## Fire Marshal Division

**RE: Anderson Creek Primary School  
914 Anderson Creek School Rd.  
Bunn Level, NC 28323**

**Re: Application Number – FMFW1905-0003**

EXISTING FIRE SYSTEM: CHANGE TANK & ADD NOZZLES FOR BRAISING PAN

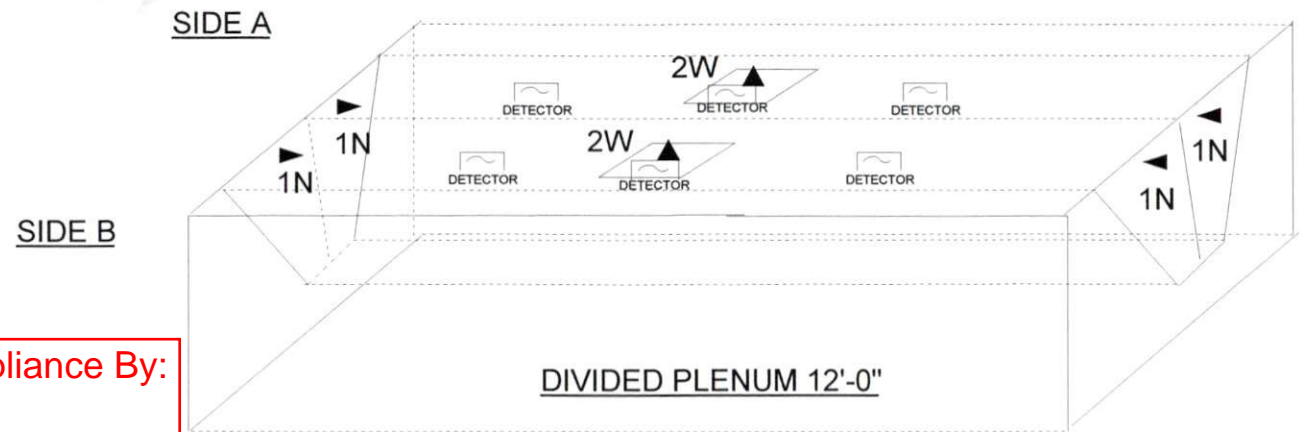
- **Commercial cooking equipment.**
  - A multi-purpose ABC type extinguisher (minimum 2A-10BC) shall be provided and mounted within 5ft. of the finished floor with a maximum travel distance of 75 ft.
  - Portable fire extinguishers shall be provided within a 30-foot (9144 mm) travel distance of commercial-type cooking equipment. Cooking equipment involving vegetable or animal oils and fats shall be protected by a Class K rated portable extinguisher.
- **Acceptance Test**
  - An acceptance test will be conducted by the Fire Marshal's office once system has been installed and pre-tested.
  - Installation shall be per architectural and system submittals and compliant with NFPA-17A.
- **Manual system operation**
  - A manual actuation device shall be located at or near a means of egress from the cooking area, a minimum of 10 feet (3048 mm) and a maximum

of 20 feet (6096 mm) from the kitchen exhaust system. The manual actuation device shall be located a minimum of 4.5 feet (1372 mm) and a maximum of 5 feet (1524 mm) above the floor. The manual actuation shall require a maximum force of 40 pounds (178 N) and a maximum movement of 14 inches (356 mm) to actuate the fire suppression system.

- The actuation of the fire suppression system shall automatically shut down the fuel or electrical power supply to the cooking equipment. The fuel and electrical supply reset shall be manual.

- Where a building fire alarm system is installed, automatic fire-extinguishing systems shall be monitored by the building fire alarm system in accordance with NFPA 72.
